from
**Southern
Water**

Our ref
PLAN-041123

Proposal: Single storey extension to replace existing conservatory.
Site: AL/95/21/HH: - 31 St Richards Road, Westergate, PO20 3RD.

GROUND FLOOR PLAN ~ AS PROPOSED

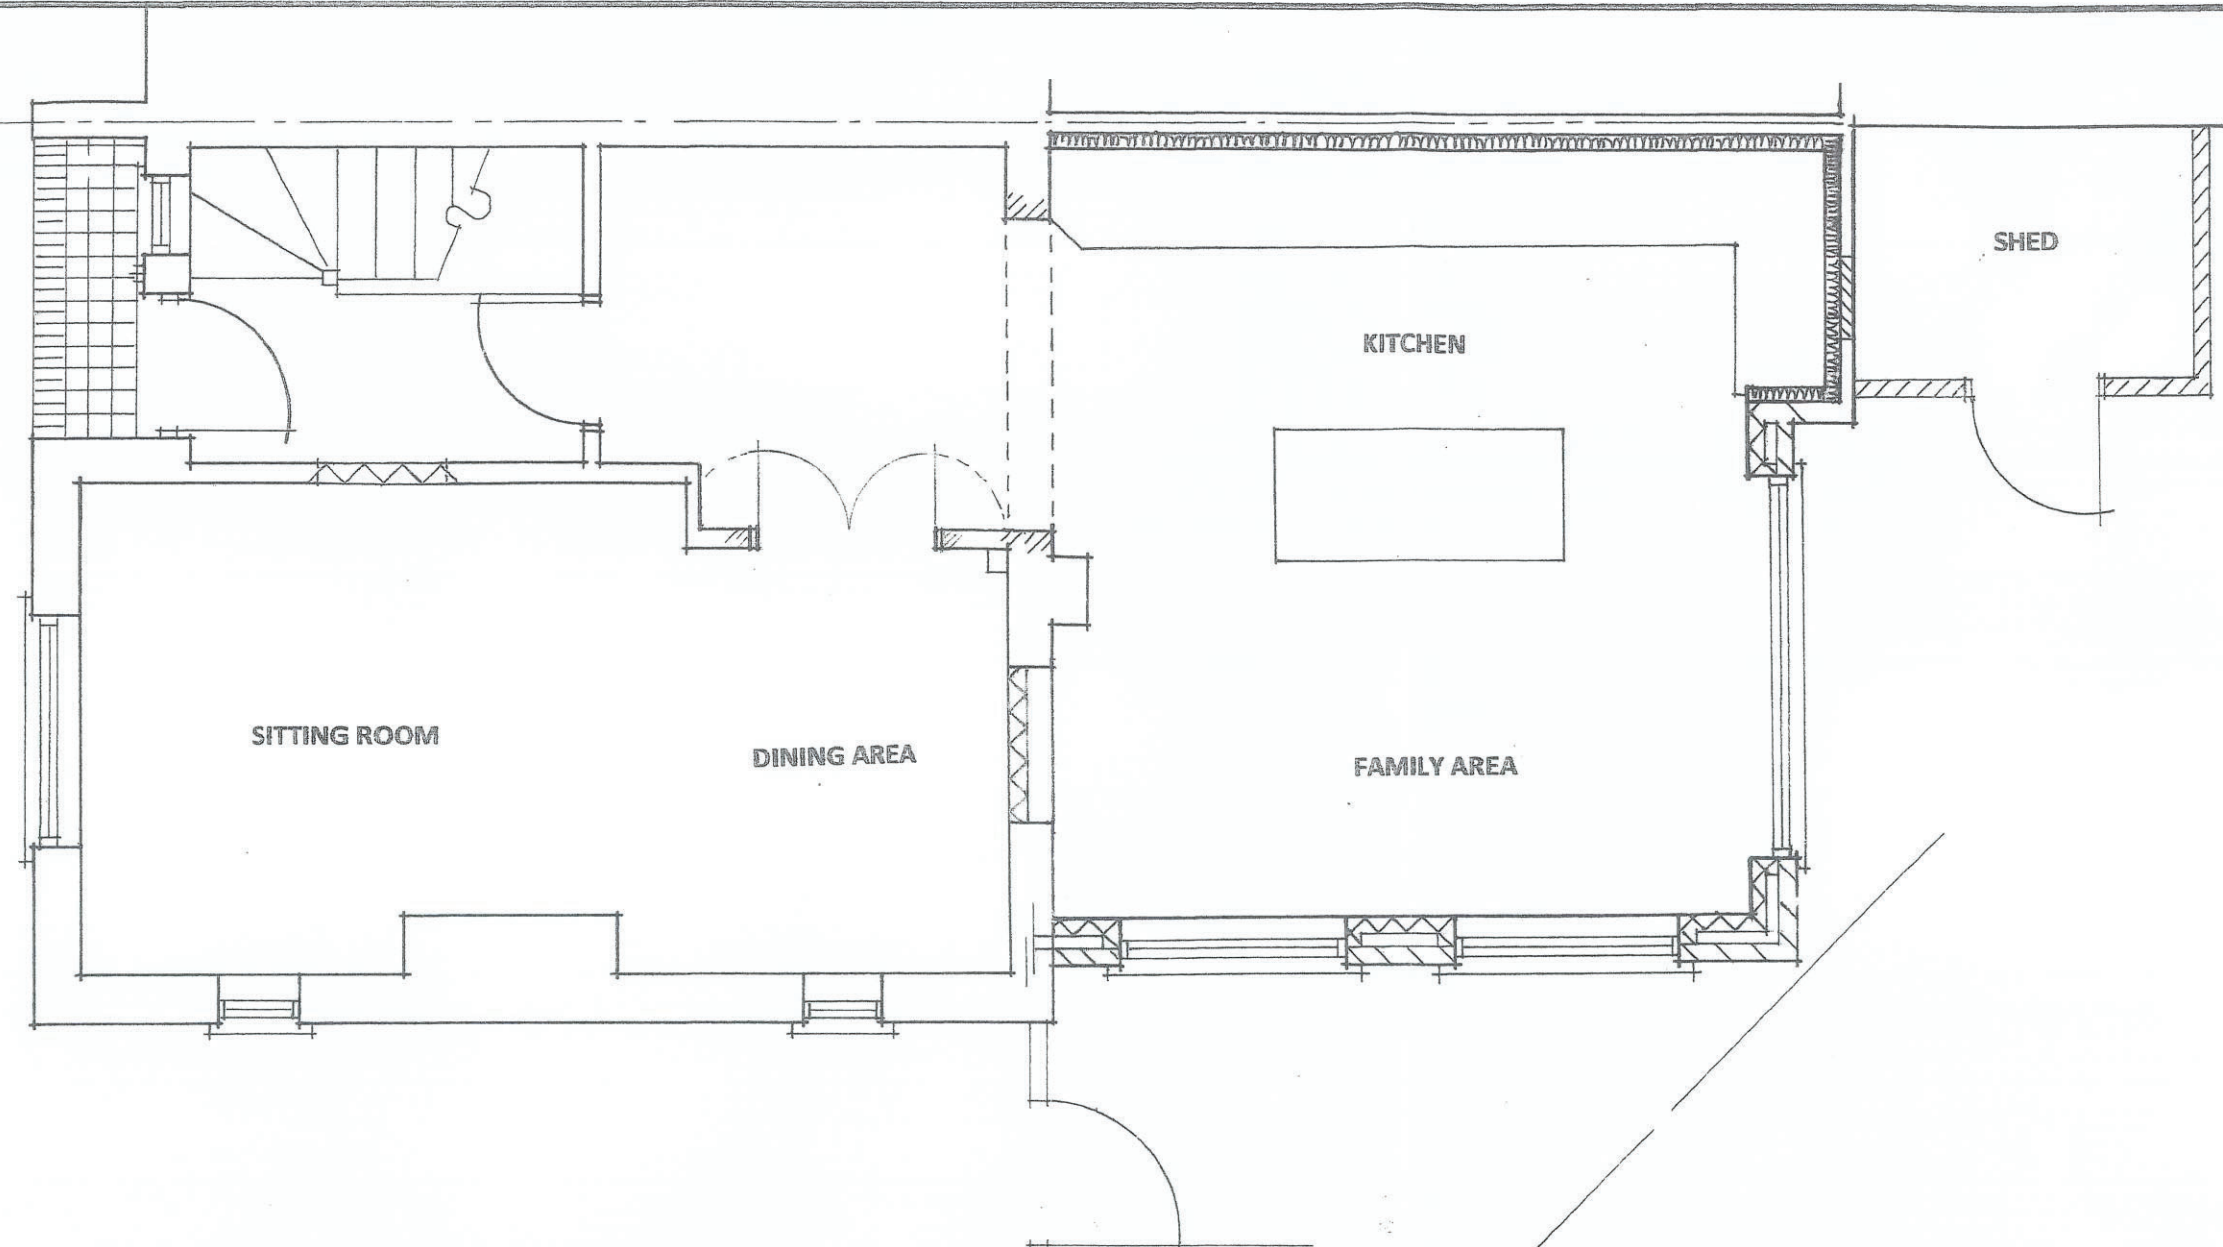
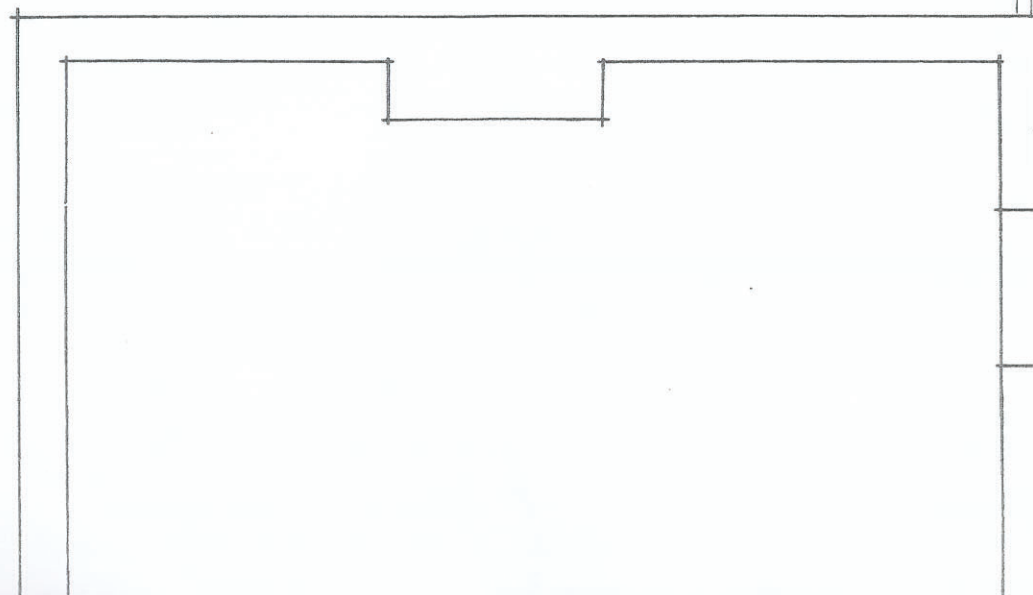
Please see the attached extract from Southern Water records showing the approximate position of our existing foul sewer crossing the development site. The exact position of the public asset must be determined on site by the applicant in consultation with Southern Water before the layout of the proposed development is finalised.

- The 150 mm diameter gravity sewer requires a clearance of 3 metres on either side of the gravity sewer to protect it from construction works and to allow for future maintenance access.
- No new excavation or new tree planting should be carried out within 3 metres of the external edge of the public gravity sewer without consent from Southern Water.
- No new soakaways, swales, ponds, watercourses or any other surface water retaining or conveying features should be located within 5 metres of public or adoptable gravity sewers.
- All existing infrastructure should be protected during the course of construction works.
